**SSD 6010 - One Residential Building (Student Accommodation) within  
Darling Drive Plot**

**Submission by:**

**Mr Don Smythe**

**21 July 2013**

SHADOW DIAGRAMS: PERSPECTIVE, SHOWING THE PEAK, WINTER SOLSTICE

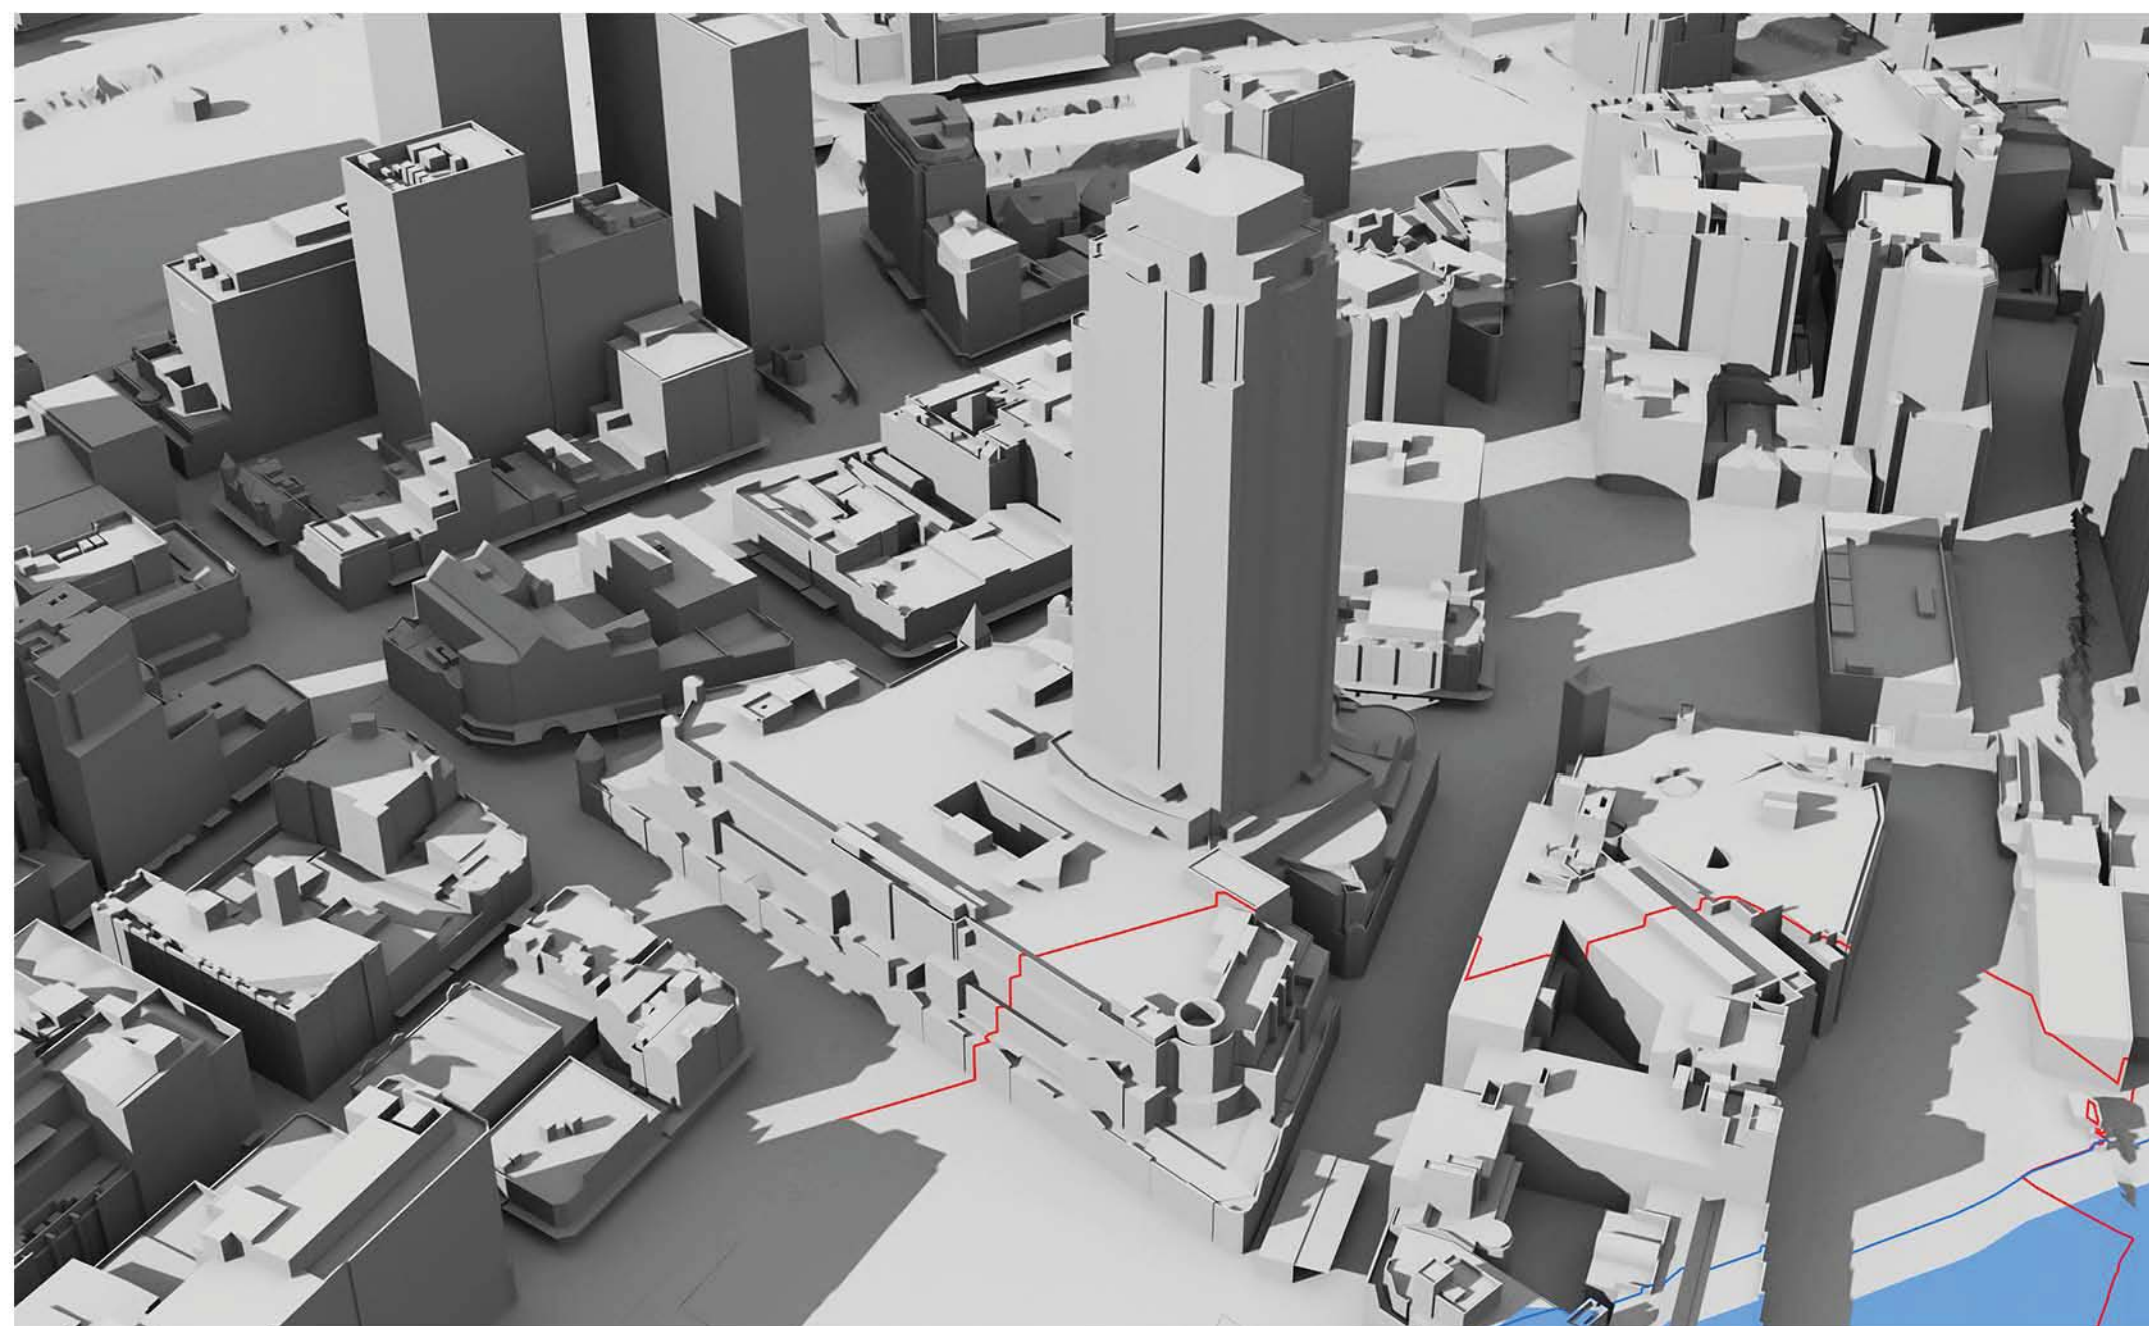
We refer to the shadow diagrams in SSD5878, Appendix H. Supplementary Design Report, Section 6. Amendments, Winter solstice - 22 June. This is not 21 June, but there would be no noticeable difference.

The south façade is not shown. On 21 June it would never receive any direct sunlight.

At 9am, 10am and 11am the west façade is totally in shadow due to other parts of The Peak building itself.

At 12pm there is still substantial existing shadowing on the west façade caused by the irregular shape of the west facade.

At 1pm the existing shadowing has been substantially removed, but not totally removed.

It can be concluded that some single aspect apartments on the west façade and some south-west dual aspect corner apartments currently receive less than 2 hours direct sunlight to habitable rooms and 50% of the private open space between 9am and 3pm on 21 June.

By 2pm the existing shadowing has been totally removed, but that is too late to achieve two hours of direct sunlight before 3pm.

At 9am, 10am and 11am the west façade is totally in shadow due to other parts of The Peak building itself.

At 12pm there is still substantial existing shadowing on the west façade caused by the irregular shape of the west facade.

At 1pm the existing shadowing has been substantially, although not entirely, removed. However, overshadowing of lower levels of the west façade by the concept proposal parameter plan shadows for the N,NE and SE plots has already started.

By 2pm the existing shadowing has been totally removed. However, overshadowing of the west façade by the SSDA4 and SSDA5 buildings has appeared and risen further up the west façade than the concept proposal parameter plan shadows for the N,NE and SE plots, which is still present.

At 3pm, the proponent states correctly that 45-45% of the western façade is overshadowed by the SSDA4 and SSDA5 buildings.

It can be concluded that, as a result of combination of the proposed development with existing shadowing of the west façade, some single aspect apartments on the west façade and the south-west dual aspect corner apartments which currently receive less than 2 hours direct sunlight to habitable rooms and 50% of the private open space between 9am and 3pm on 21 June will suffer additional overshadowing. It is beyond our skills to count the number of such apartments. We note that the proponent has made no attempt to do so.
